WEST SUSSEX COUNTY COUNCIL CONSULTATION

TO:	Arun District Council FAO:Simon Davis
FROM:	WSCC - Highways Authority
DATE:	7 November 2019
LOCATION:	75 Highfield Road Bognor Regis PO22 8PD
SUBJECT:	BR/301/19/DOC Approval of details reserved by condition imposed under ref BR/129/19/PL relating to Condition Nos 4 - site set up, 6 - screen wall and/or fences, 8 - secure cycle parking, 9 - electric charging and 10 - renewable & low carbon energy.
DATE OF SITE VISIT:	n/a
RECOMMENDATION:	Advice / No Objection / Objection / More Information / Modification / Refusal
S106 CONTRIBUTION TOTAL:	n/a / £ See below for breakdown.

Discharge of condtions 4,6,8 and 9

75 Highland Rd. 109. Dr 11-11-11-
Drawing No. 1

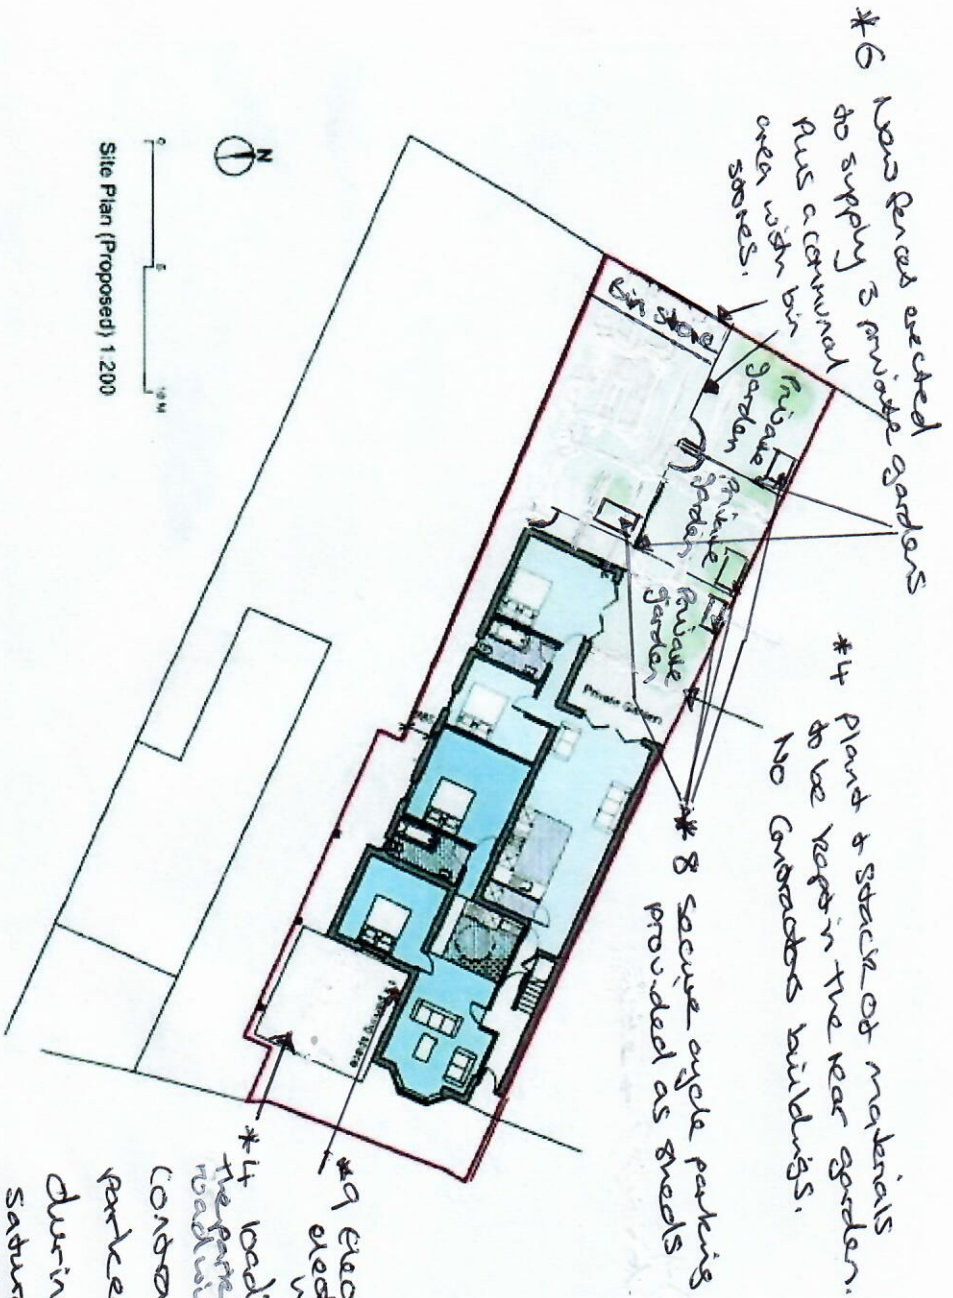
Details have been provided and no objection is raised.

4 – Loading and Unloading will take place in parking bays to front of property.
Use of road for contractor parking.

6 – Loading area to be rear gardens where materials will be stacked

8 – bikes will be stored in sheds.

9 – EVC charging point on wall
